Arun District Council Planning Objections

Having just examined the planning applications Numbers LU/221/14/PL -222 -223 -224 - and 227 with prefix and suffix the same, the writer would comment as follows.

NORTH ELEVATION

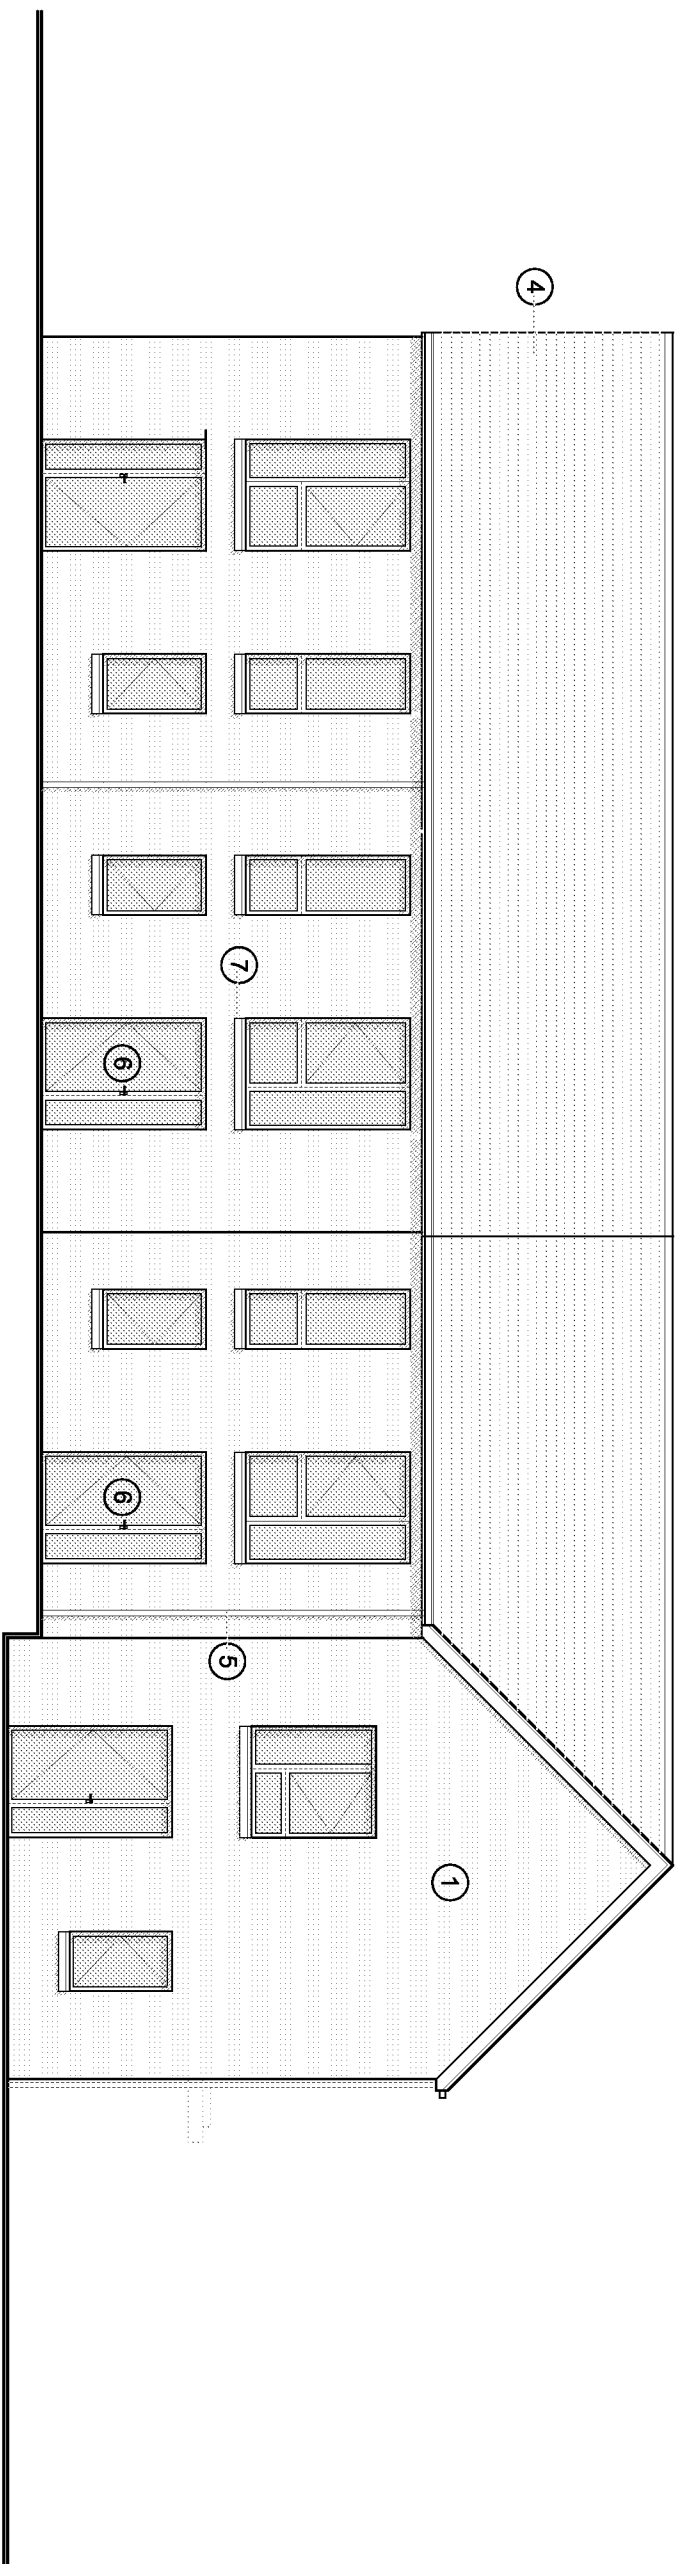
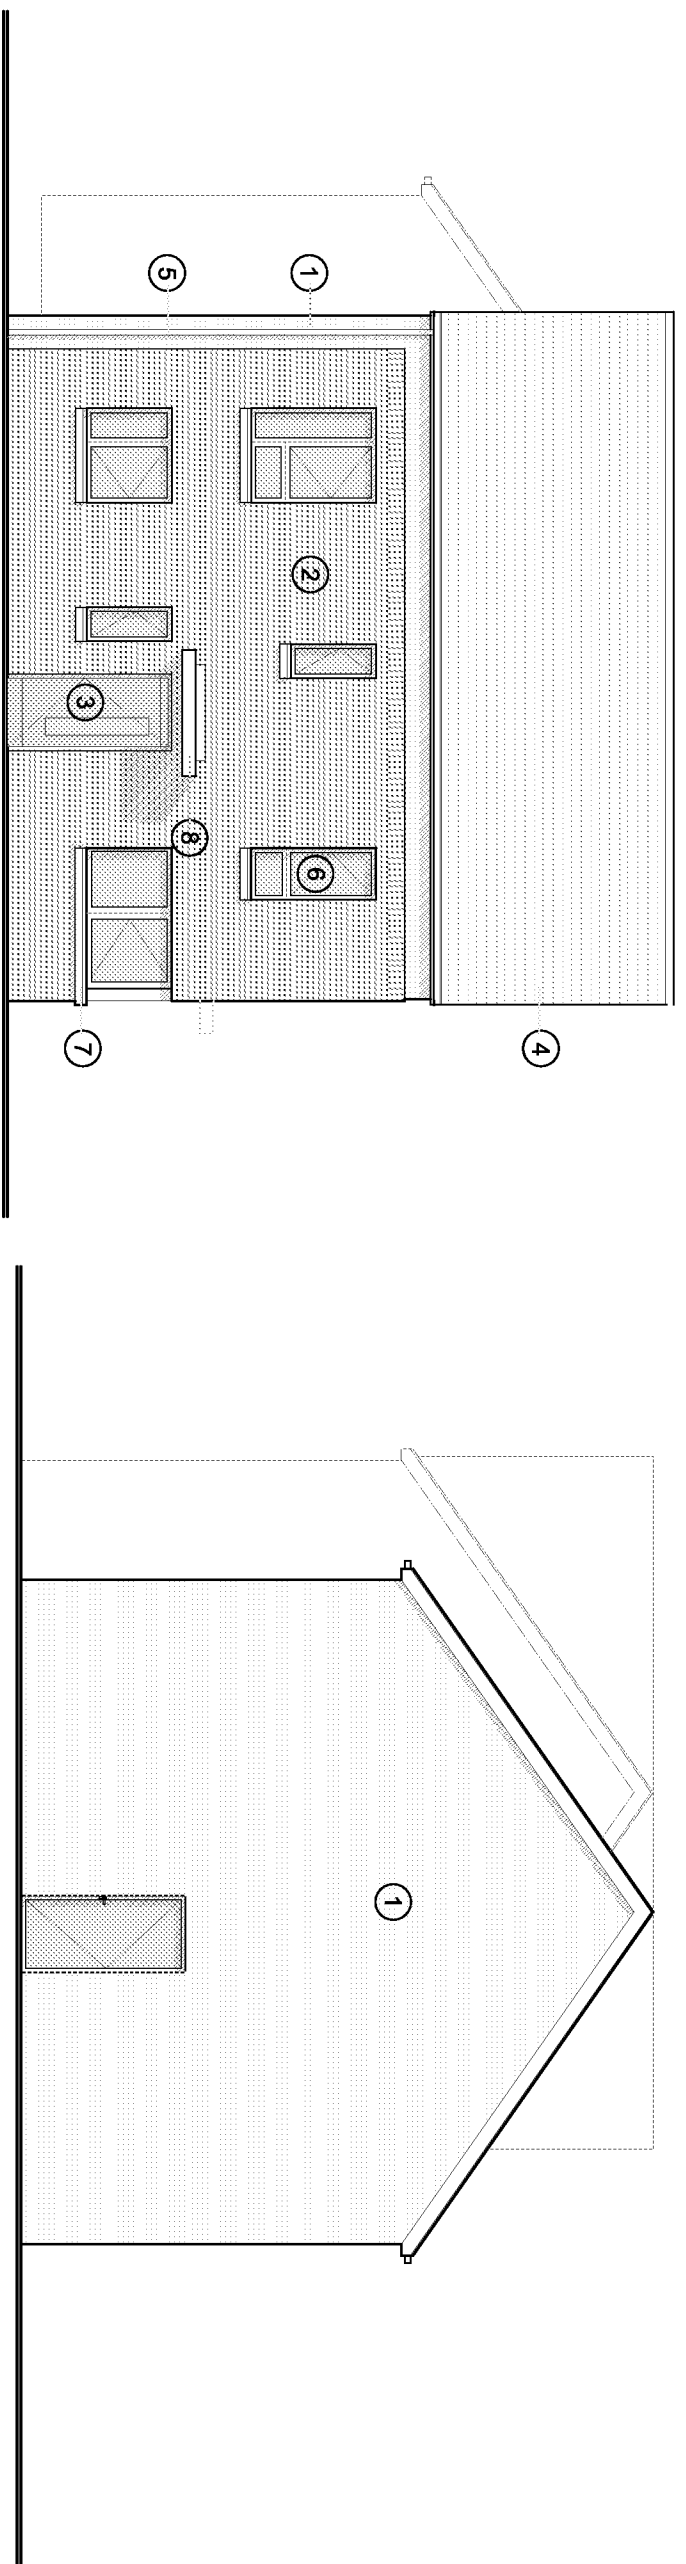
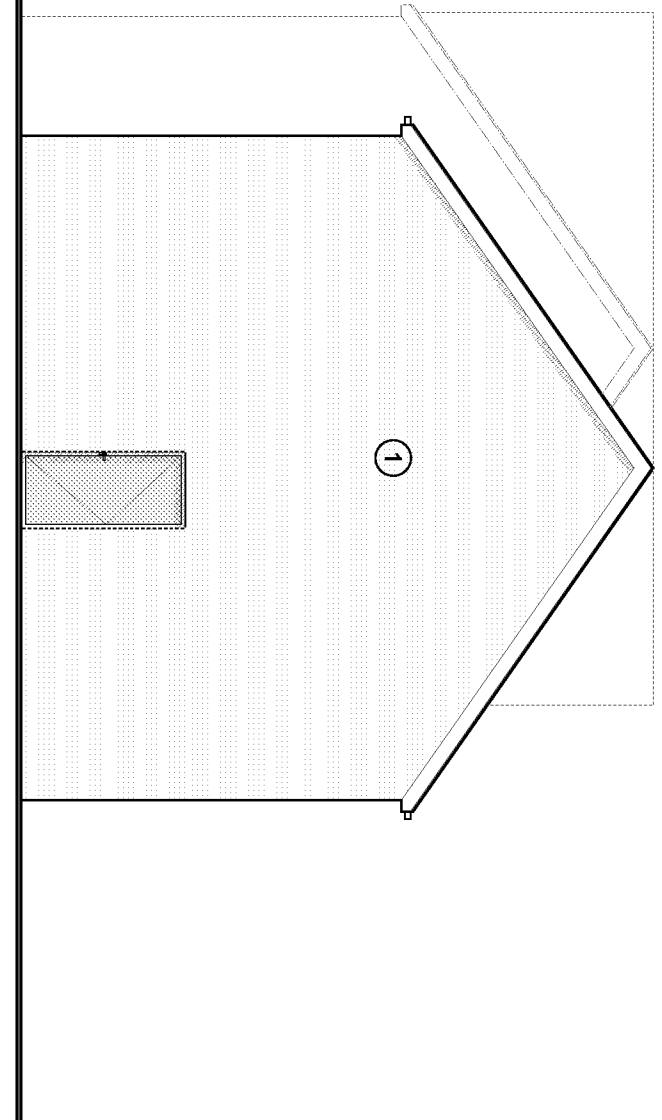
As there is a short distance from a number of the proposed houses north elevations, up to the dog walk, what provision is being made to ensure easy and safe access/egress for the disabled to use the external doors, to compensate for the different elevations?

The drawings also give no indication as to if level ground, to the south elevation entrance doors are to be in place.
